Office of Water

11 August 2010

Our ref: MPER 21111
Your ref: MP 10_0073

Subject: Sandvik Machinery Manufacture and Maintenance Project, Heatherbrae (MP 10_0073)

Project No
10096C
 Drawing No
C01
 Revision
5

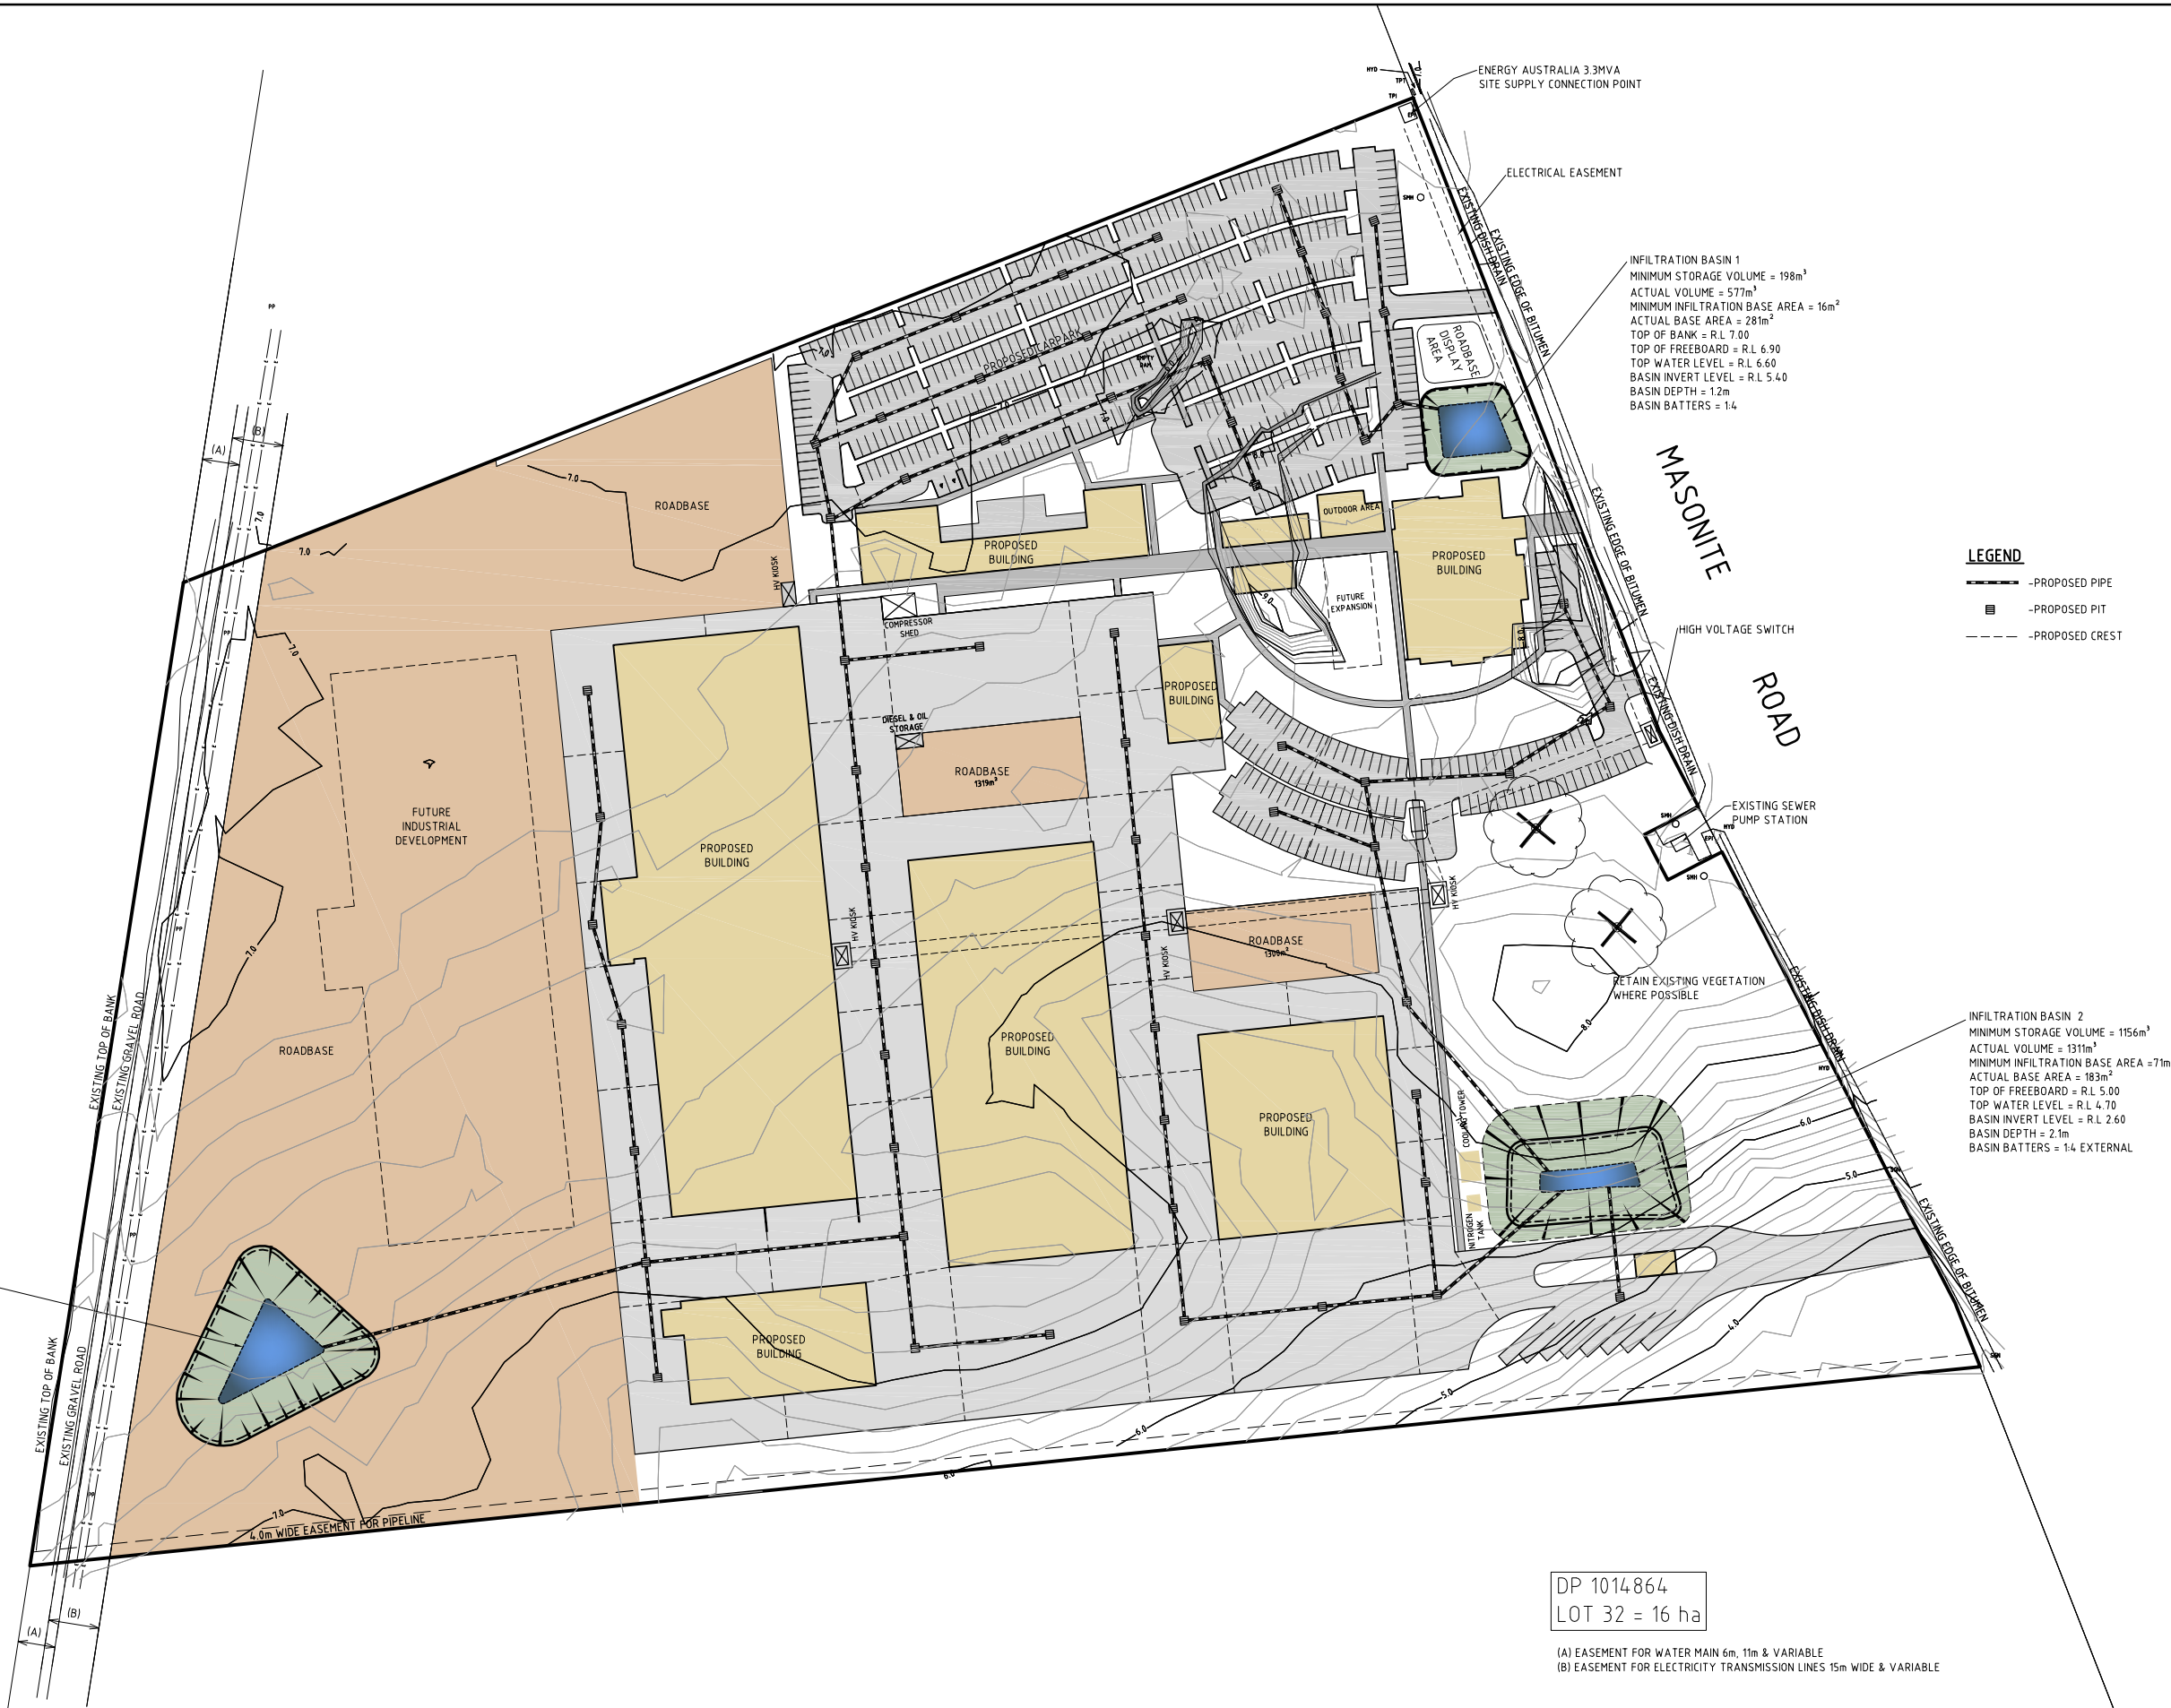
The project proposes stormwater infiltration basins which pose a risk to the groundwater, which is of high quality and a groundwater source from which Hunter Water extracts. The environmental assessment does not provide sufficient information on the treatment of the stormwater runoff prior to disposal to the infiltration basins and the proposed water quality that will enter the aquifer via the infiltration basins.

- The proposal details bulk storage of diesel and waste oil, which poses a pollution threat to the groundwater if a spill occurs. The environmental assessment does not detail whether the diesel and waste oil will be stored within a bunded area and the specification of the design.

- Specific design details and location of the stormwater treatment systems;
- Expected water quality (through modelling or otherwise) that will enter groundwater through infiltration basins;
- Water quality monitoring locations and schedule to ensure stormwater treatment systems are functioning as per design;
- Details regarding the proposal's impacts in relation to dewatering and the provision of the Water Sharing Plan for the Tomago Tomaree Stockton Groundwater Sources 2003 (WSPTTSGS); and
- Bunding design and capacity for any potentially harmful chemical on site.
